**RHS RESPONSE TO HE'S REP10-003
(9.108 Applicant's comments to Deadline 9 submissions dated June 2020)**

HE's Section 4 (HE's comments to RHS's document Appendix 2 – AQ / BIOD comments on REP8-022 [REP9-013])

Figure 1: Wisley & Ockham Commons Management Plan 2010 – 2020 management prescriptions for woodland clearing / felling shown with the 150m buffer zone from the roads

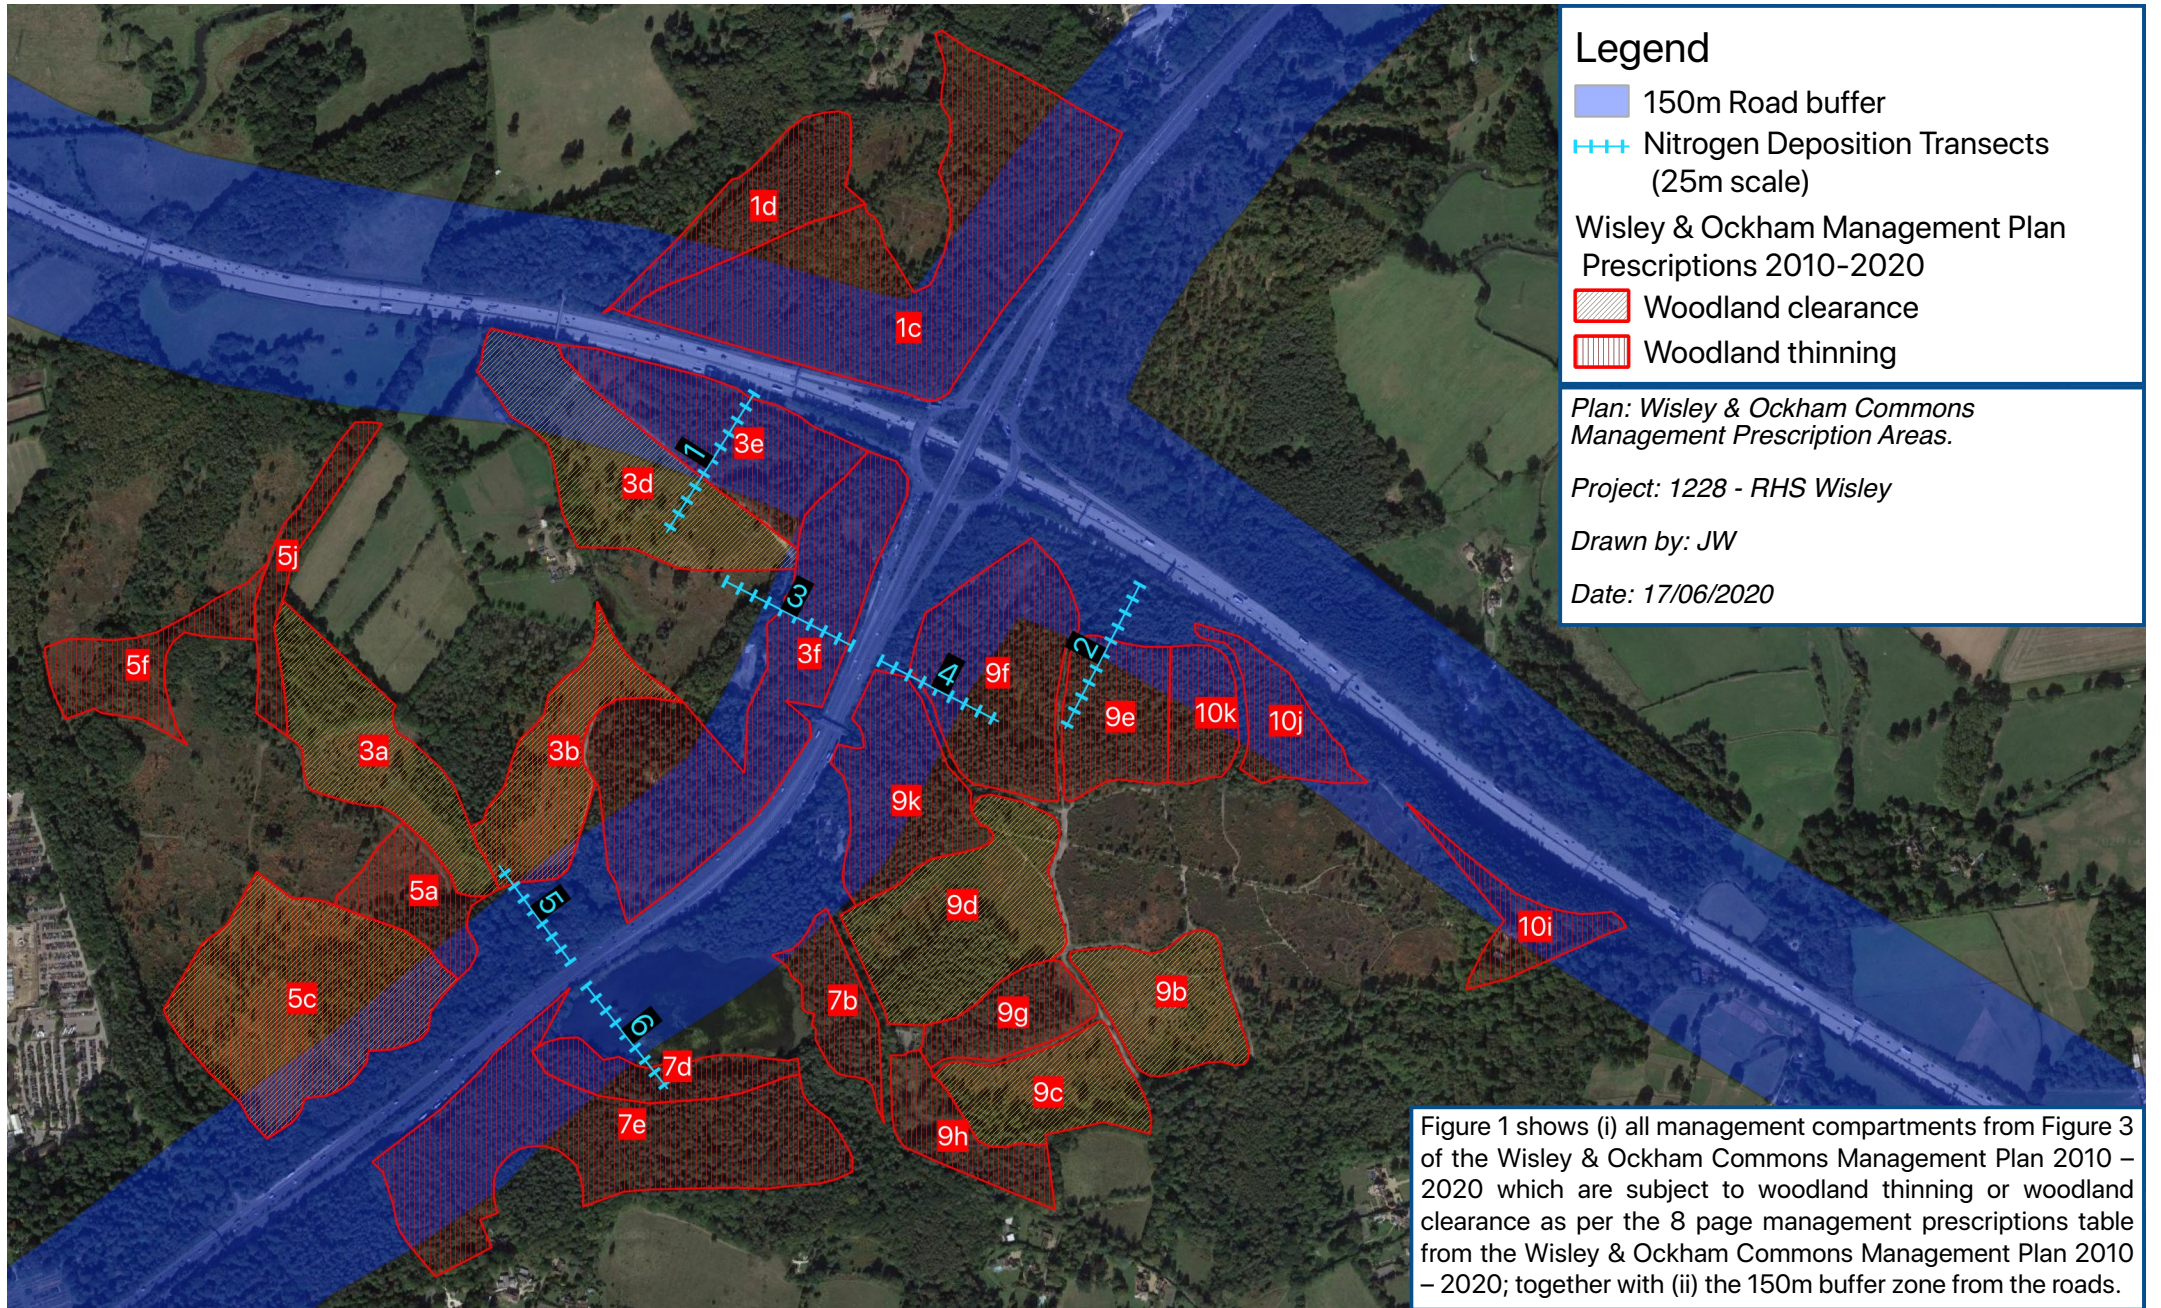
14. RHS now refers to the Baker Consultants Ltd Figures 1-4 and to Baker Consultants Ltd's Table 1 (attached to RHS's deadline 11 response to the ExQ4 answers given by HE / NE and Surrey WT). These show that HE's purported compensatory measures in its SPA Enhancement Areas are in very large part already envisaged under the Wisely and Ockham Commons Management Plan 2010-2020 and in some cases represent a down grading from what is envisaged in the Wisely and Ockham Commons Management Plan 2010-2020.
